Your Ref: OWPC21079
Our Ref: WA/89/18/L 12-10-2018
Please ask for:
Zac Denton

Listed building consent for a replacement 1.19m high privacy screen, affixed to the existing 0.48m high dwarf wall giving a total height of 1.81m to North and West sides of patio.

9 Walberton Park Walberton

Drawing / Elevation
of replacement
Privacy Screen
above existing
dwarf Wall

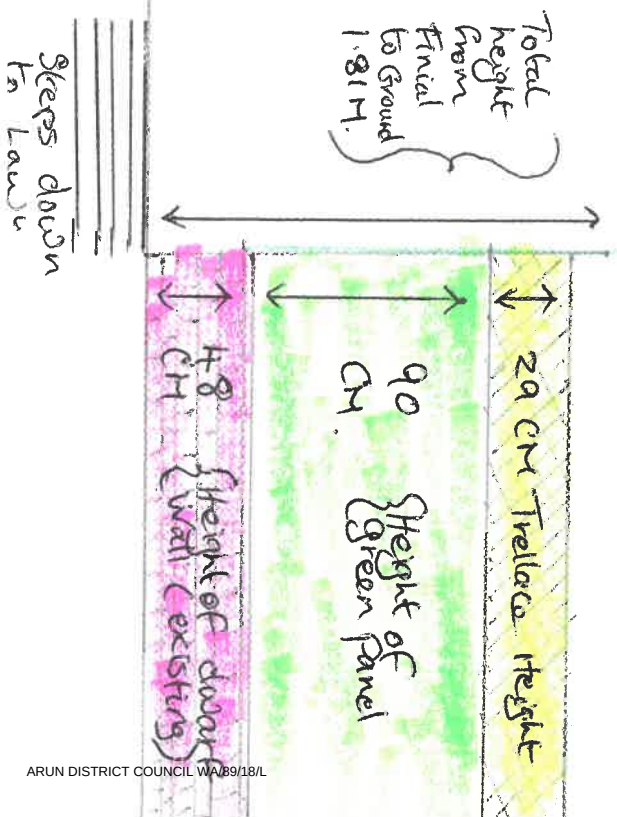
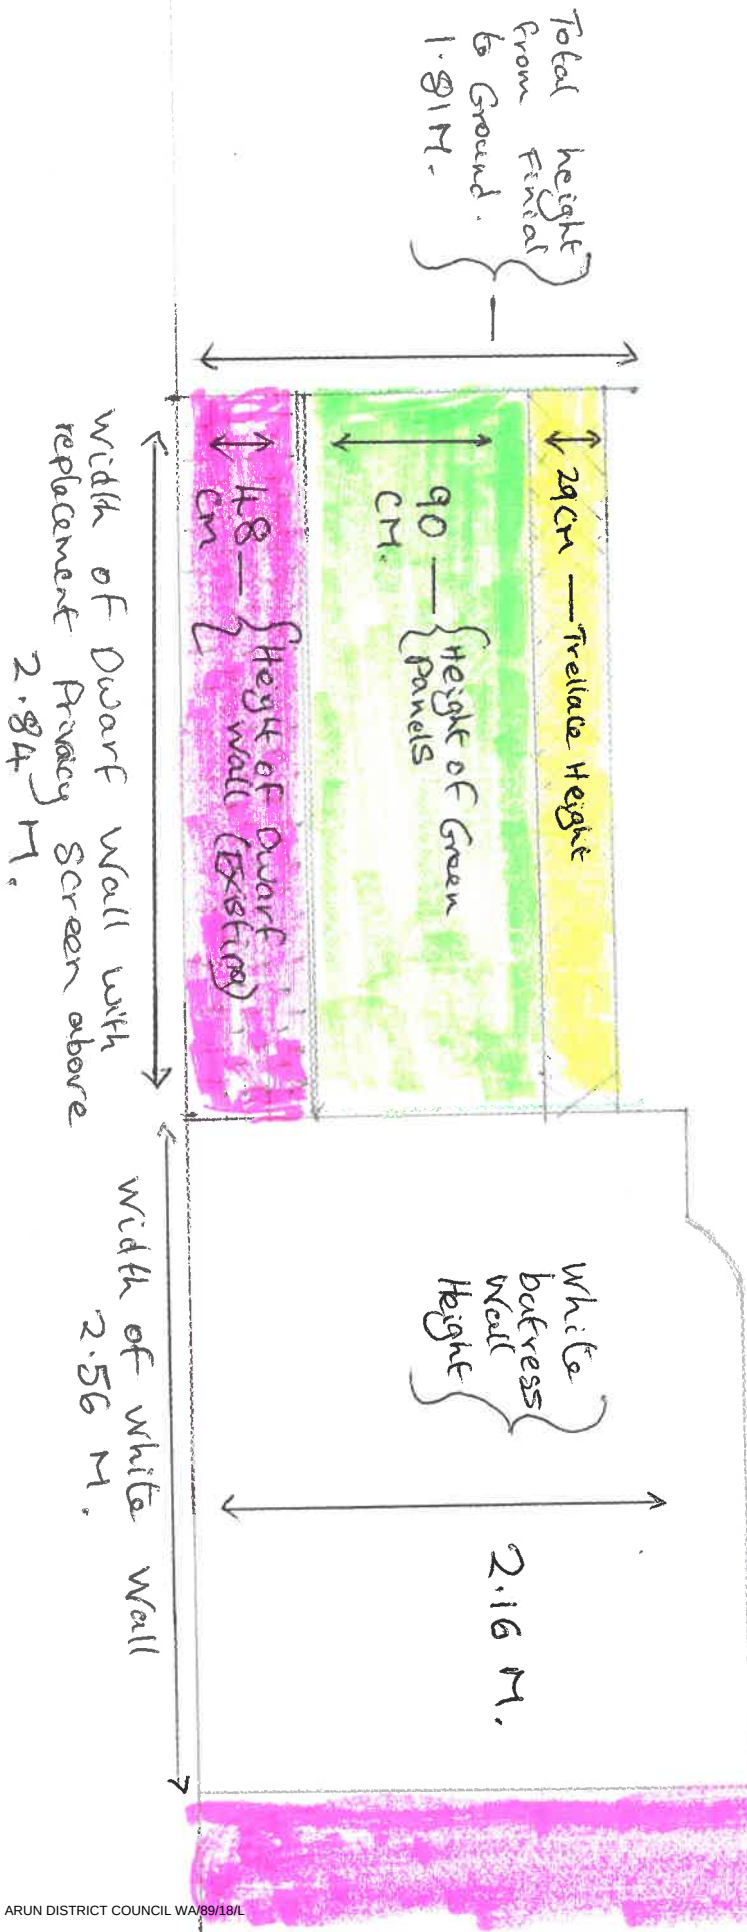
The painted metal fence which is erected on top of a low patio wall is ugly and completely inappropriate in the setting of a Grade 11 Listed property which is set in a Conservation area. It sets a precedent which other residents could follow.

We understand there has never been a structure of any kind affixed to the top of this patio wall and therefore is not a like for like replacement.
